CITY OF ALBUQUERQUE

August 25, 2016

**Re: First Baptist Church Addition
4101 Paseo Del Norte
Request Temporary 30-Day C.O. - Accepted
Engineer's Stamp dated: 2-16-16 (C12D017)
Certification dated: 8-23-16**

DRAINAGE CERTIFICATION

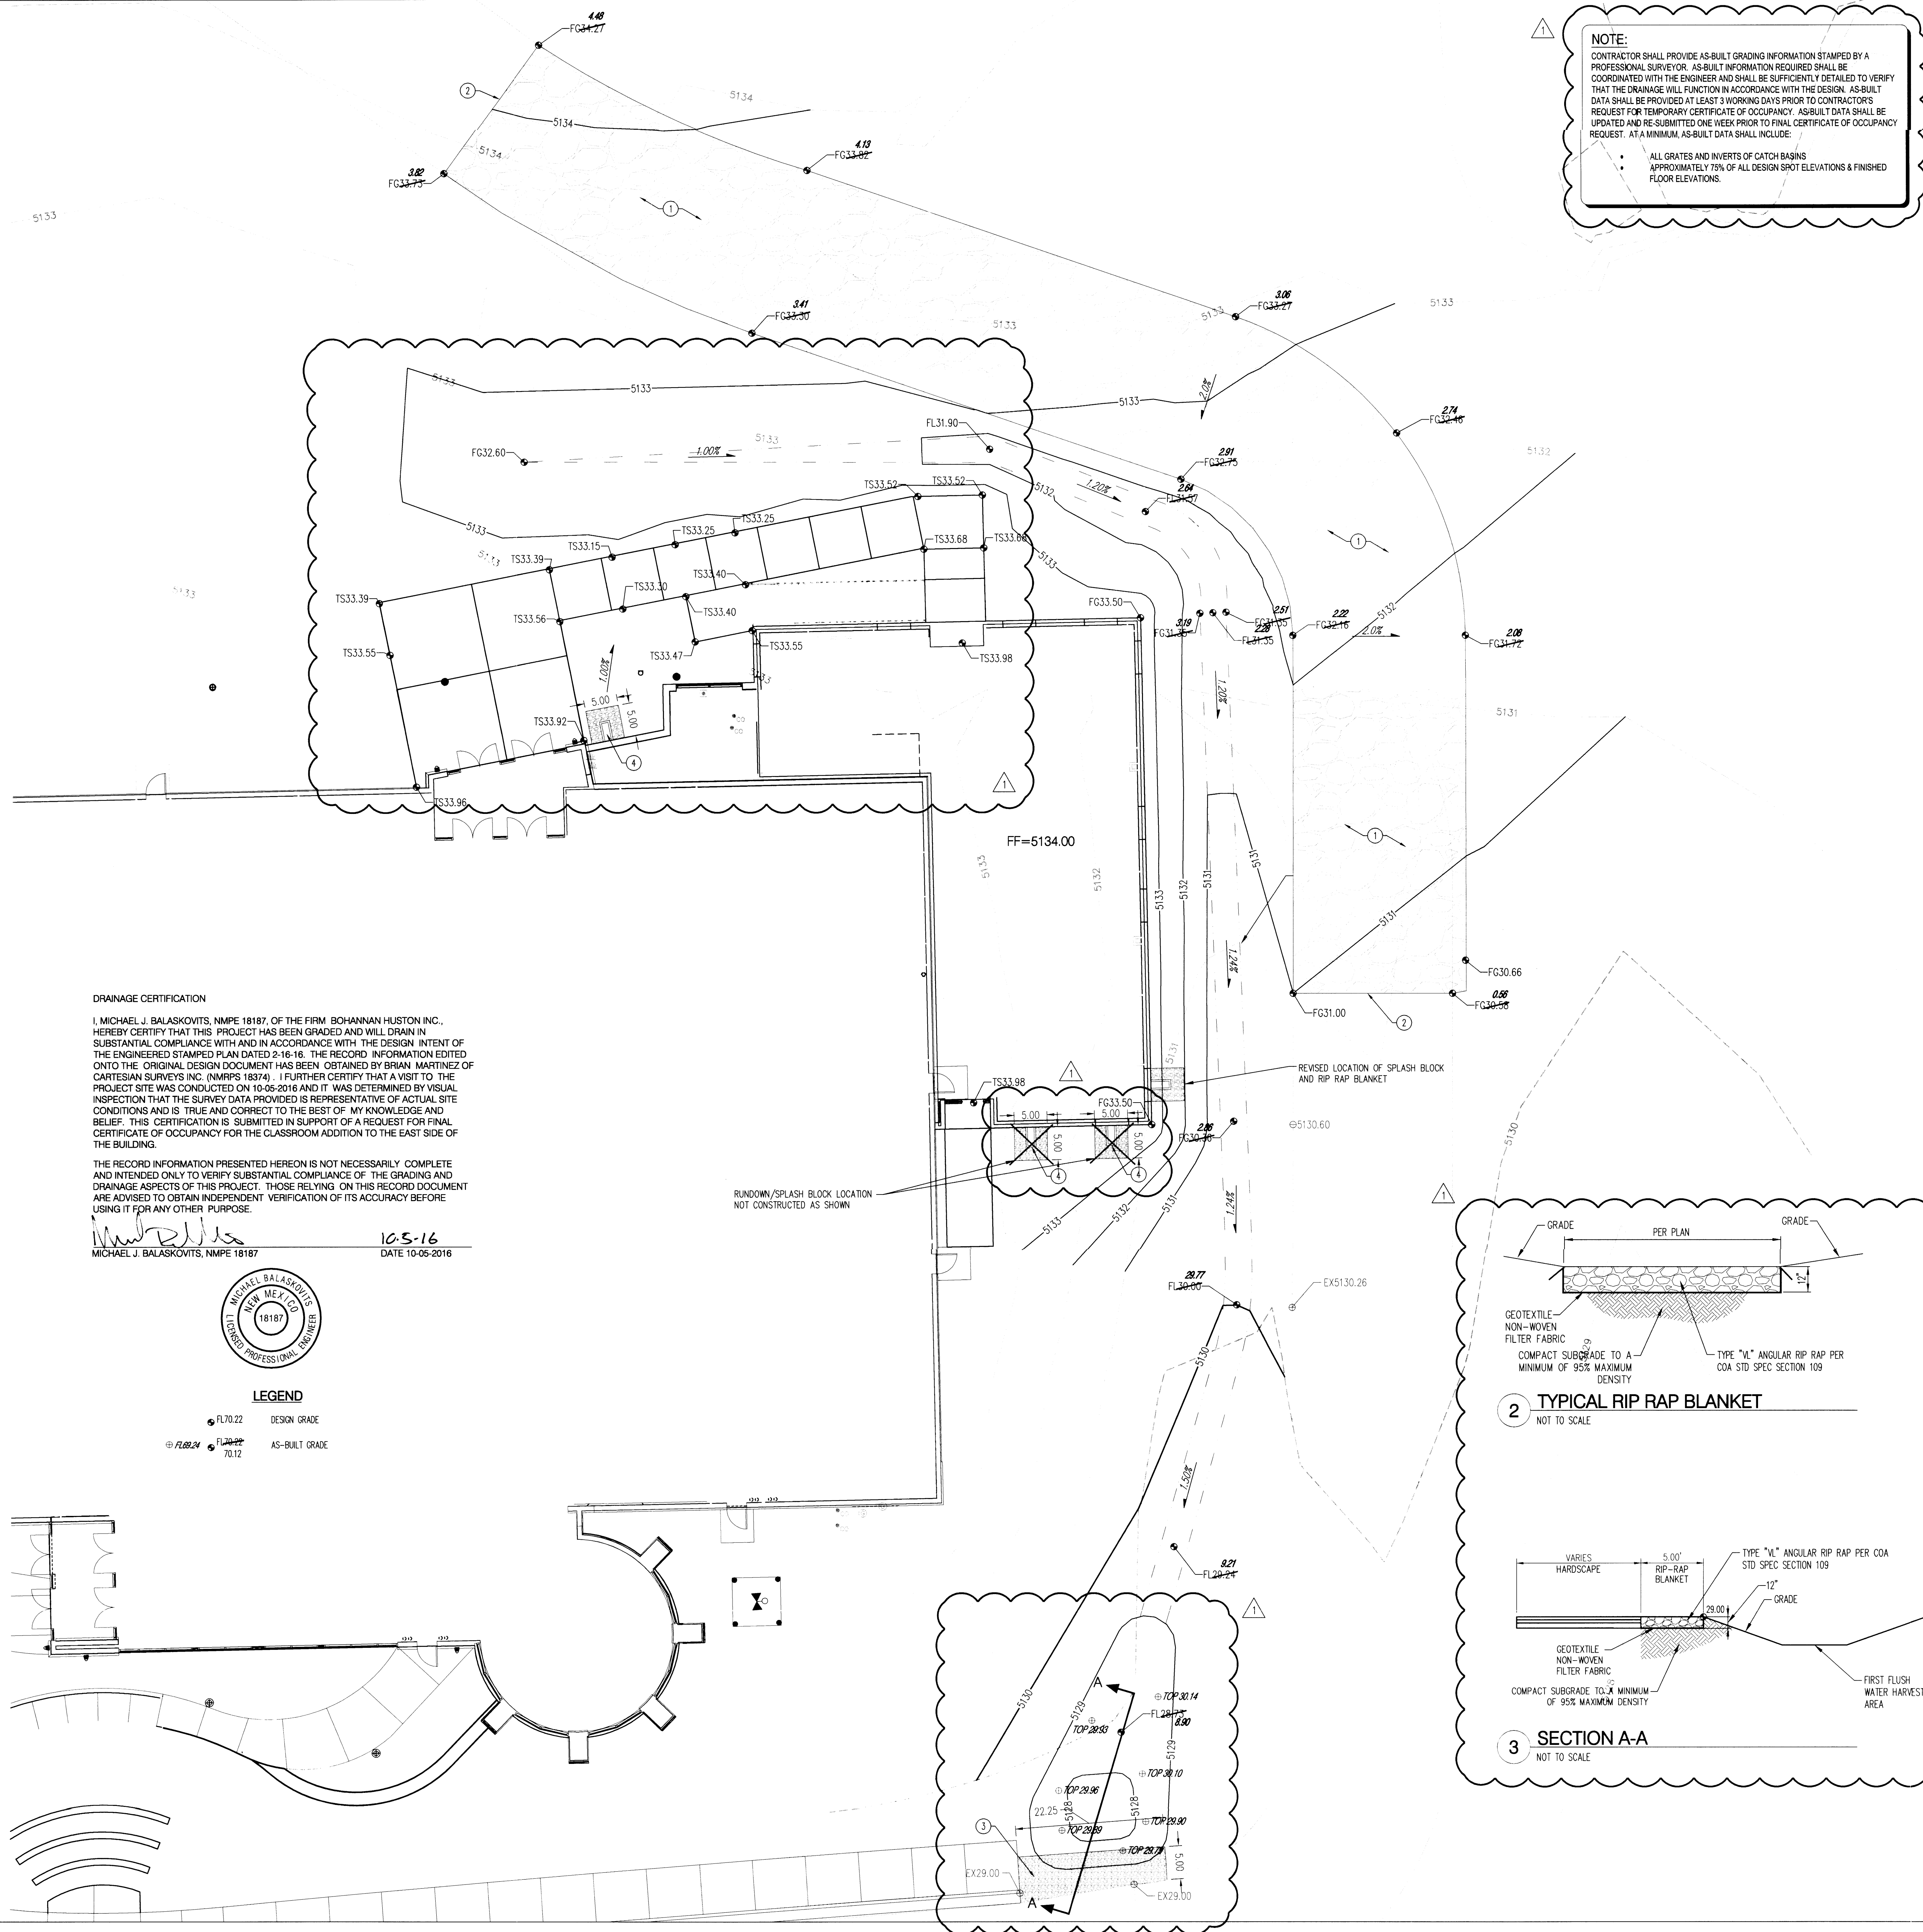
- The as-built drawing needs to reflect the actual number and location of the splash blocks.
- Geotextile non-woven filter fabric needs to be placed under the splash block and extend up around the sides. There is considerable erosion taking place underneath both splash blocks.
- The splash block on the north side of the building needs to have the rip-rap extended to all 3 sides to slow down the erosion.
